**Russell Vale Underground Expansion (MP09\_0013)  
Extraction Plan**

**Subject: Russell Vale Underground Expansion - Extraction Plan, Water Management Plan (incorporating Groundwater Management Plan) & Swamp Monitoring Program**

**Subject:** Russell Vale Underground Coal Mine Stage 2 Extraction Plan – Request for Information

## Russell Vale Underground Coal Mine – Stage 1 and 2 Extraction Plan

Figure 3 –Subsidence effects monitoring installations and LiDAR coverage area for natural and built features (source Umwelt 2022)

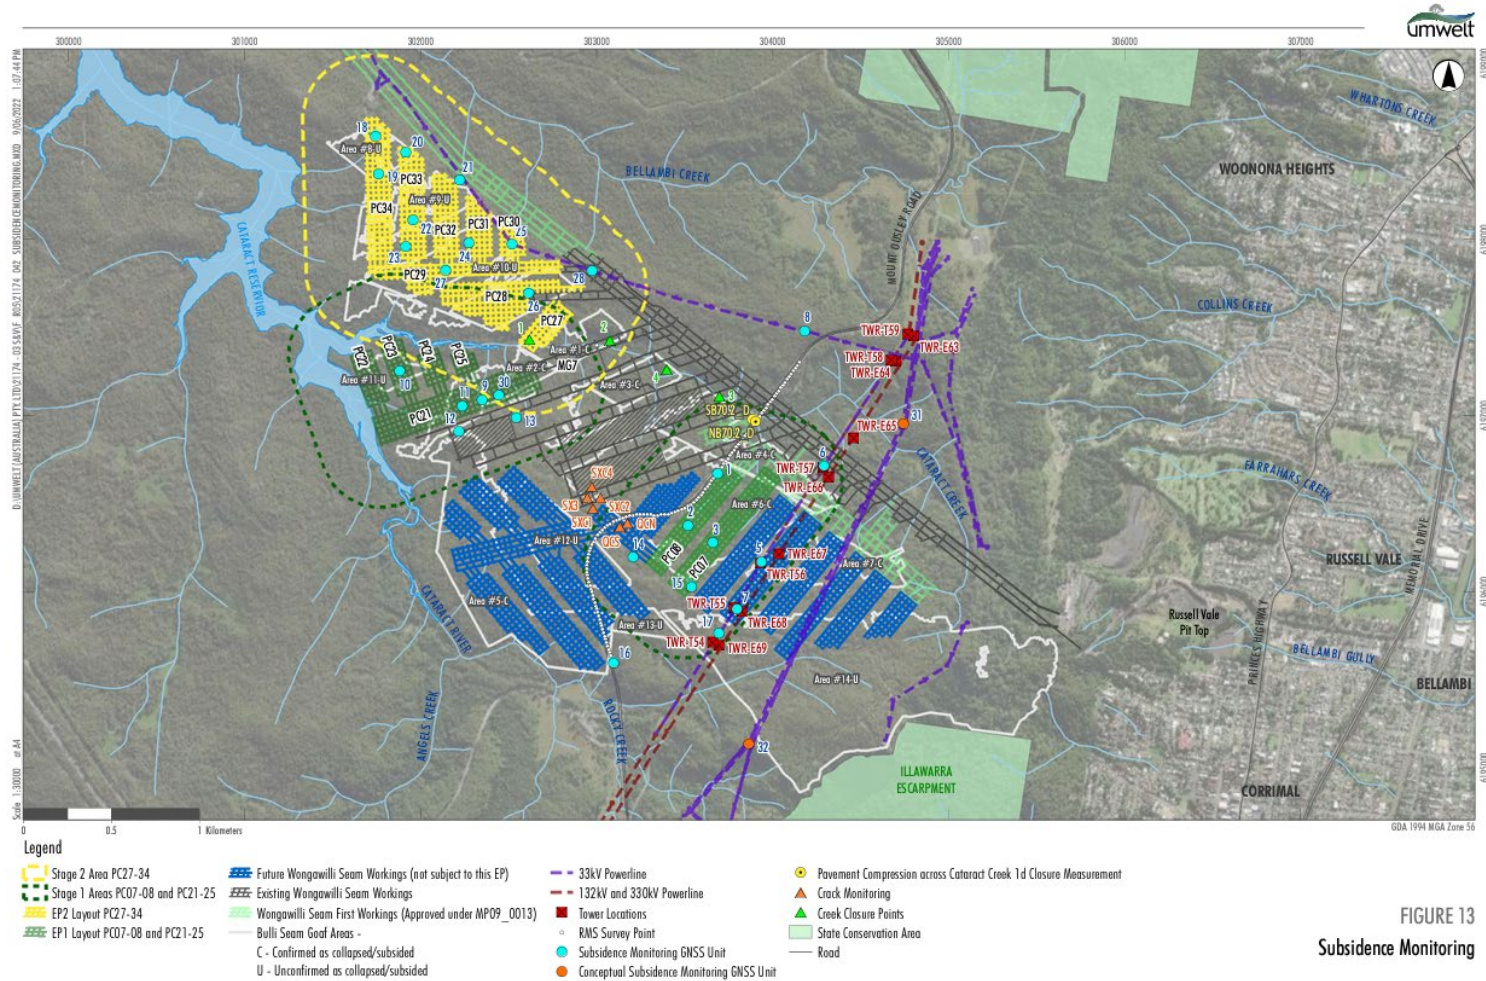
The proposed GNSS locations are mapped on Figure 11a of the Upland Swamp Monitoring Plan (USMP). Table 13 of the USMP details the subsidence monitoring relevant to Coastal Upland Swamps. The relevance/purpose of GNSS units is described as:

- located over second workings to provide information about subsidence occurring within that panel
- located within or at the edge of swamps provide an indication of subsidence levels within the swamp
- where possible, located at a point within the swamp or at a point between the swamp and the second workings

The department requests WCL identify which GNSS units are intended for one or more of the purposes outlined in Table 13 of the USMP.

Figure 4 – Performance Measure TARP Process

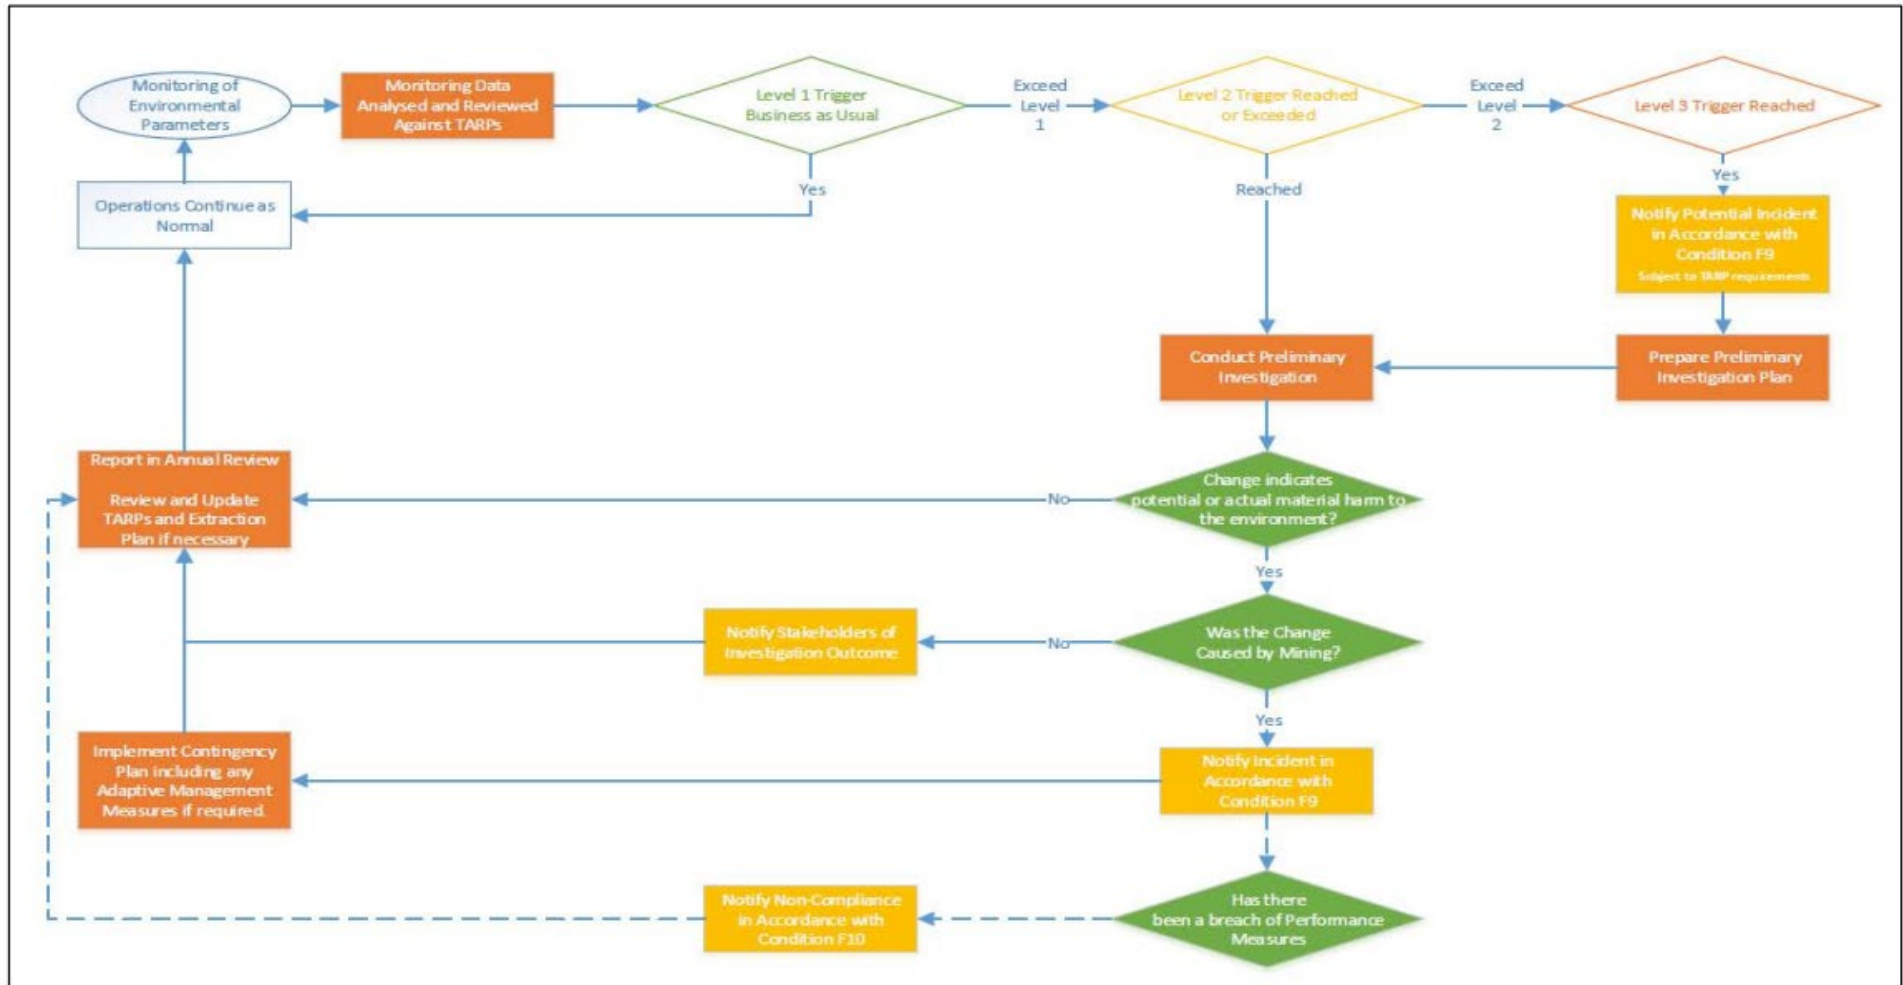
Consider including a dispute resolution step in the TARP for instances where there may be differing opinions in relation to the cause of any exceedance. Additionally, Figure 15 – Flow

chart box should consider a process for dispute resolution in the event there is conflicting opinion between agency and stakeholder as to whether the impact is/isn't mining related.

GNSS #31 – 132 kV Powerline

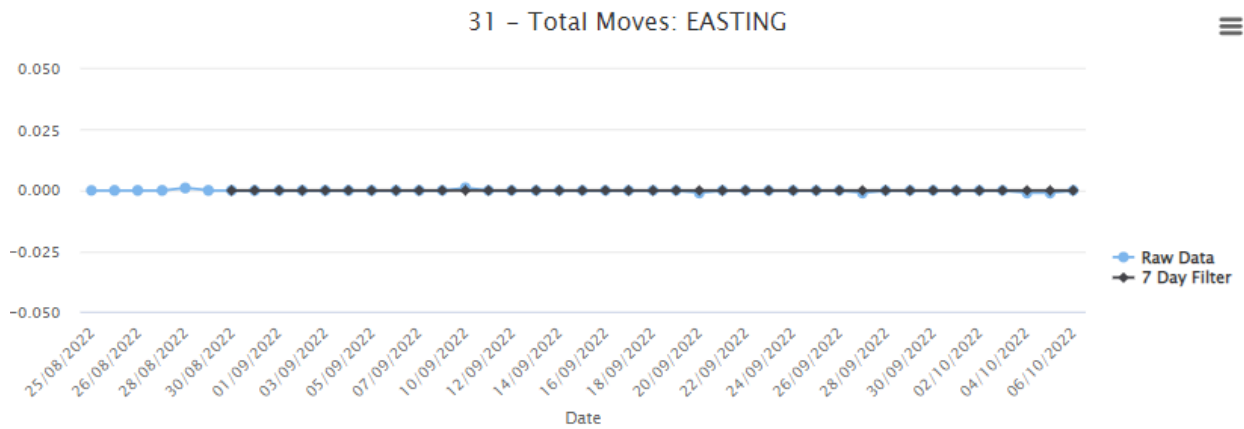
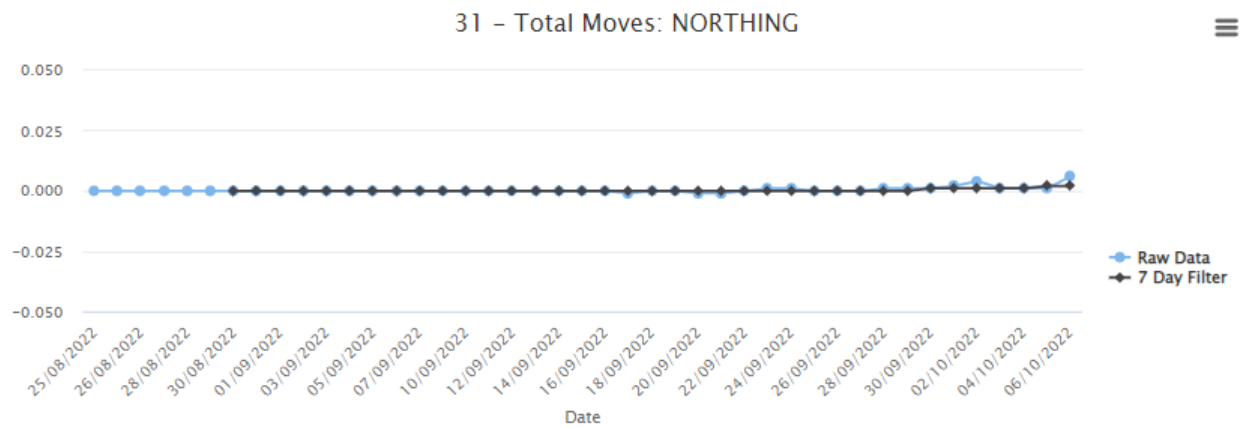
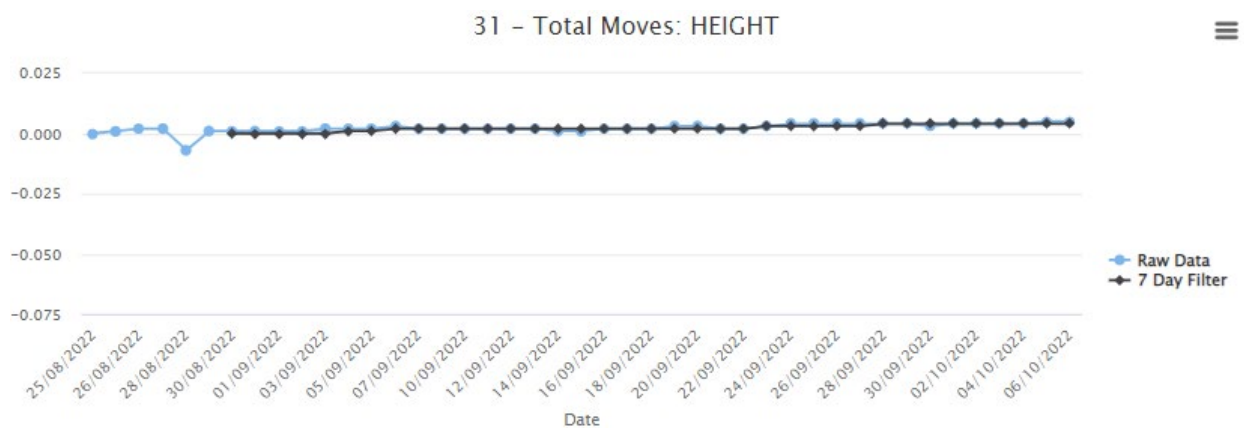
## **GNSS Units #31 and #32**
